From: Andrew Wood
Sent: 16 May 2019 10:09
To: Planning.Responses
Subject: LU/11/19/DOC - The Locomotive Inn, 5 Terminus Road - Landscaping Condition

LU/11/19/DOC - The Locomotive Inn, 5 Terminus Road - Landscaping Condition

LANDSCAPING

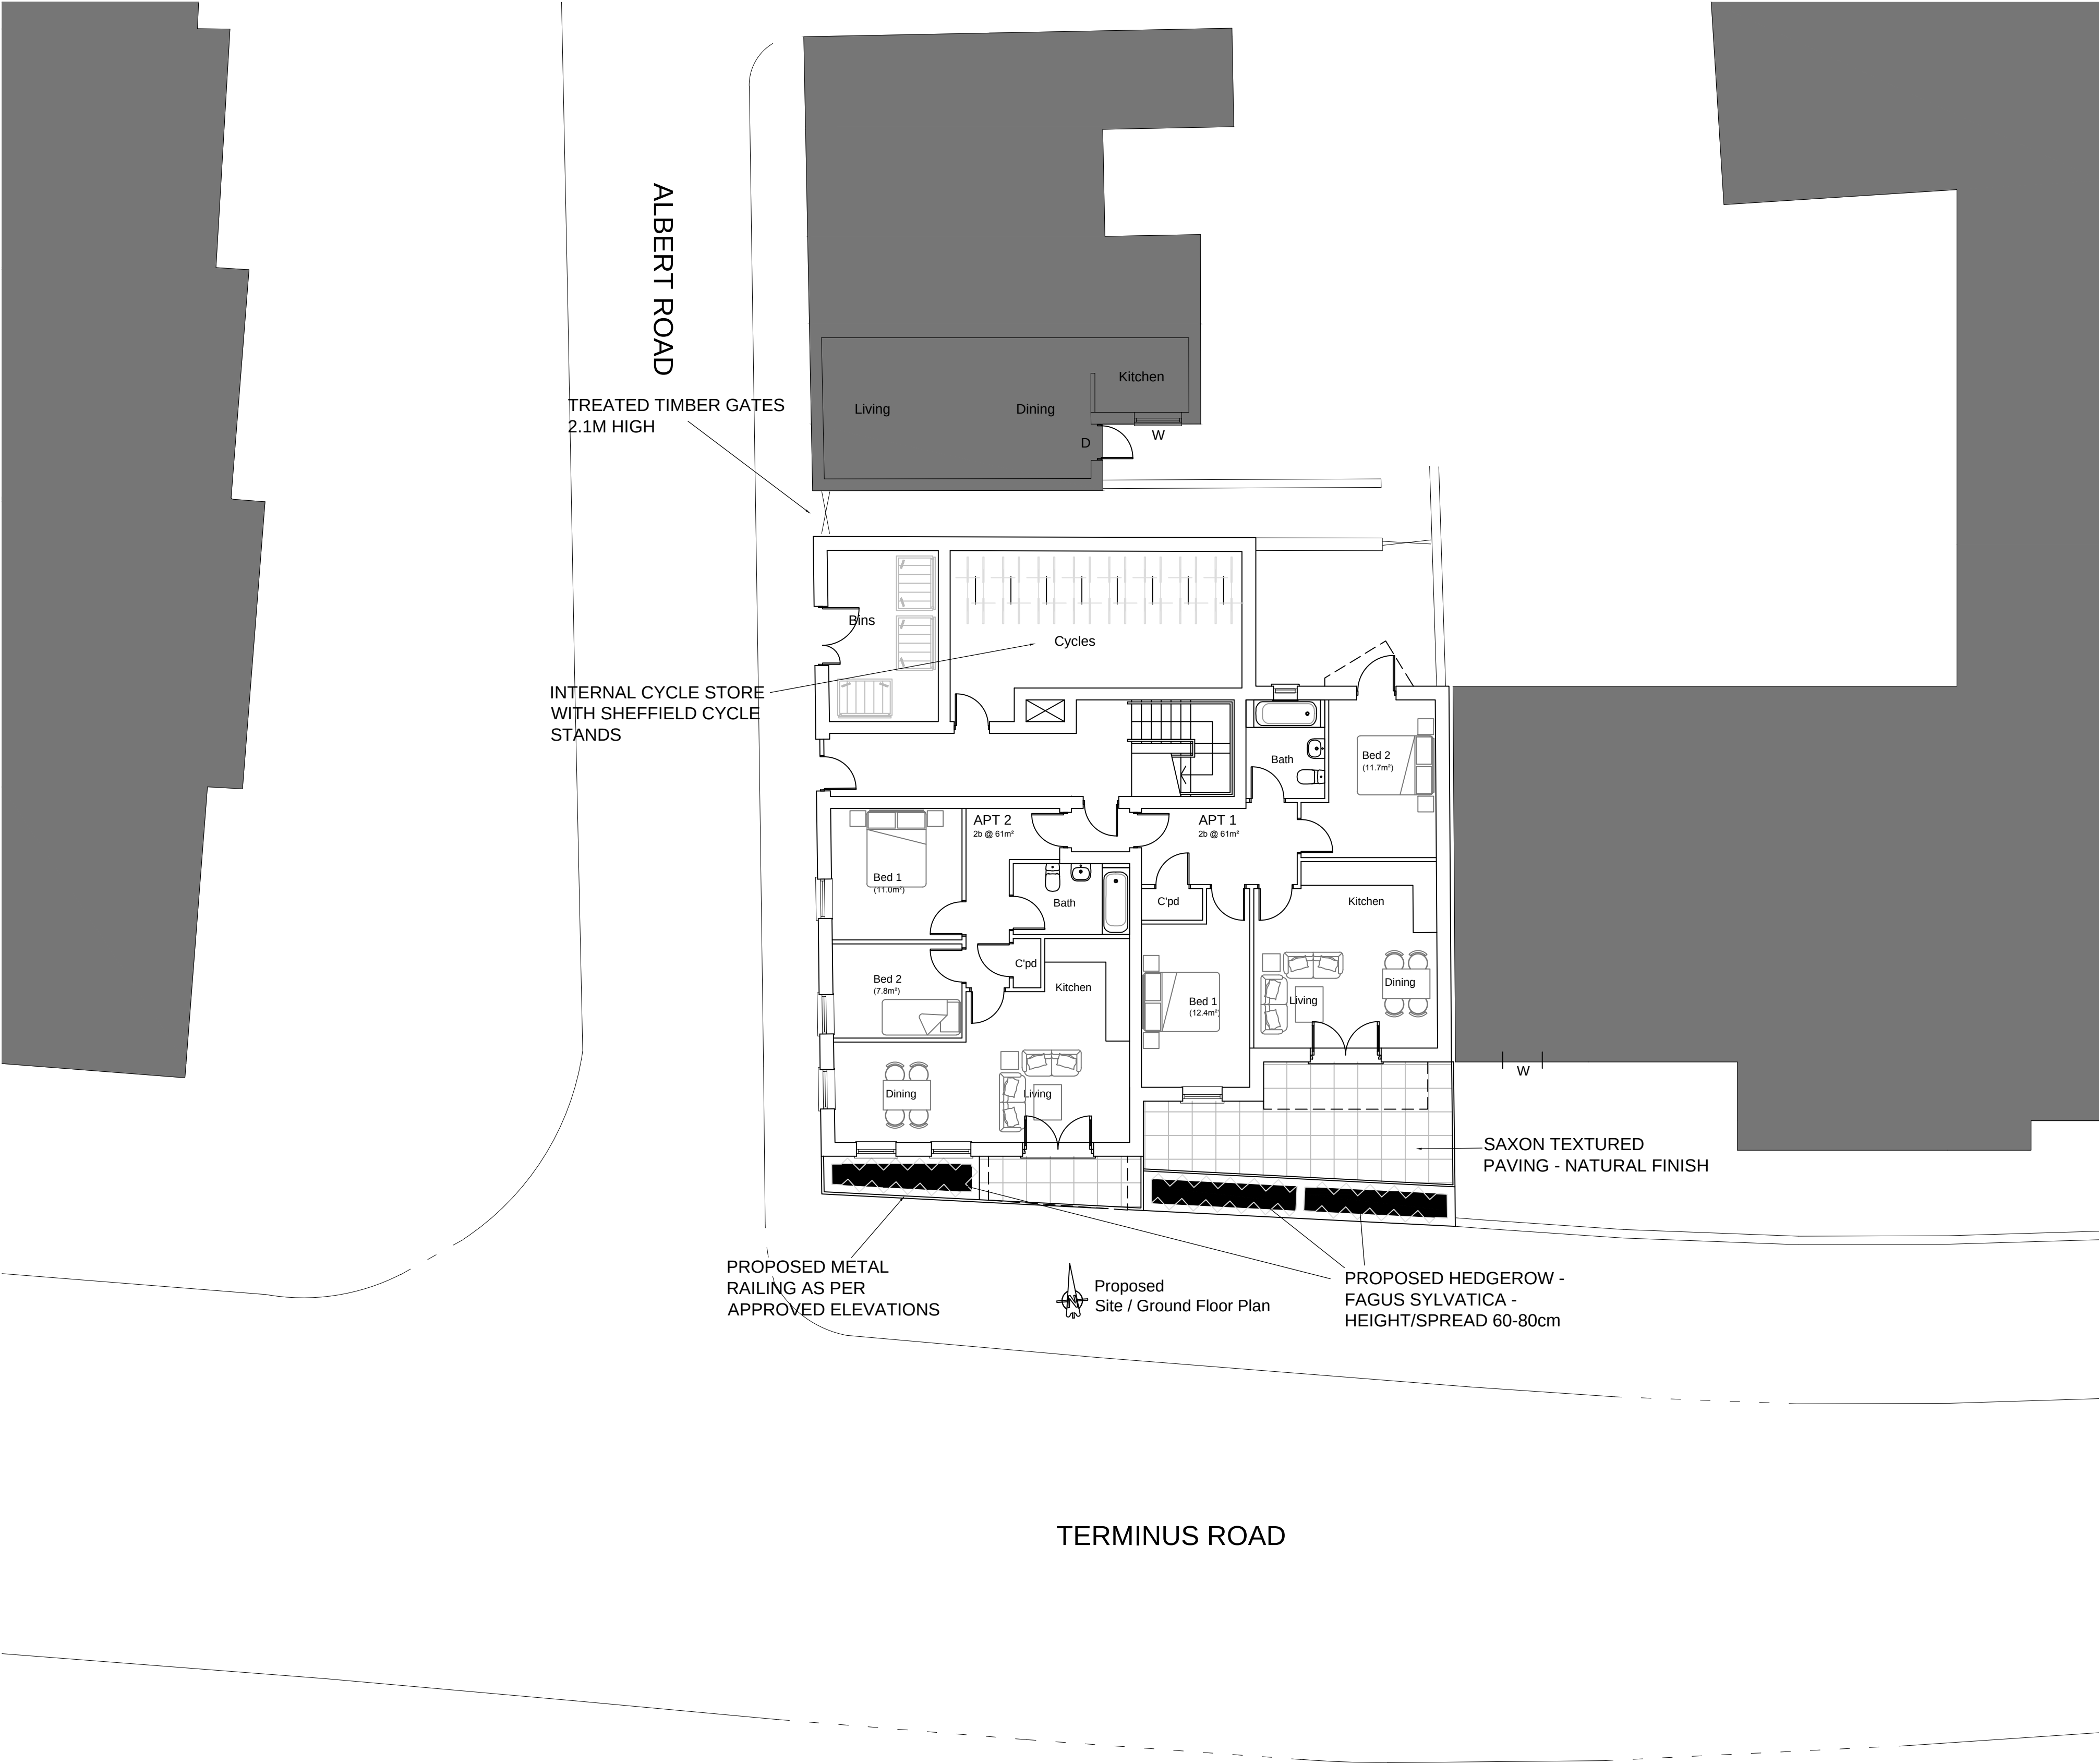
You have requested that the agent provides plant quantities and densities. However, given that the hedging height and species is specified I consider that compliance could be achieved if necessary and the soft landscaping only amounts to a single hedge, I intend to recommend the condition for discharge on this particular occasion.
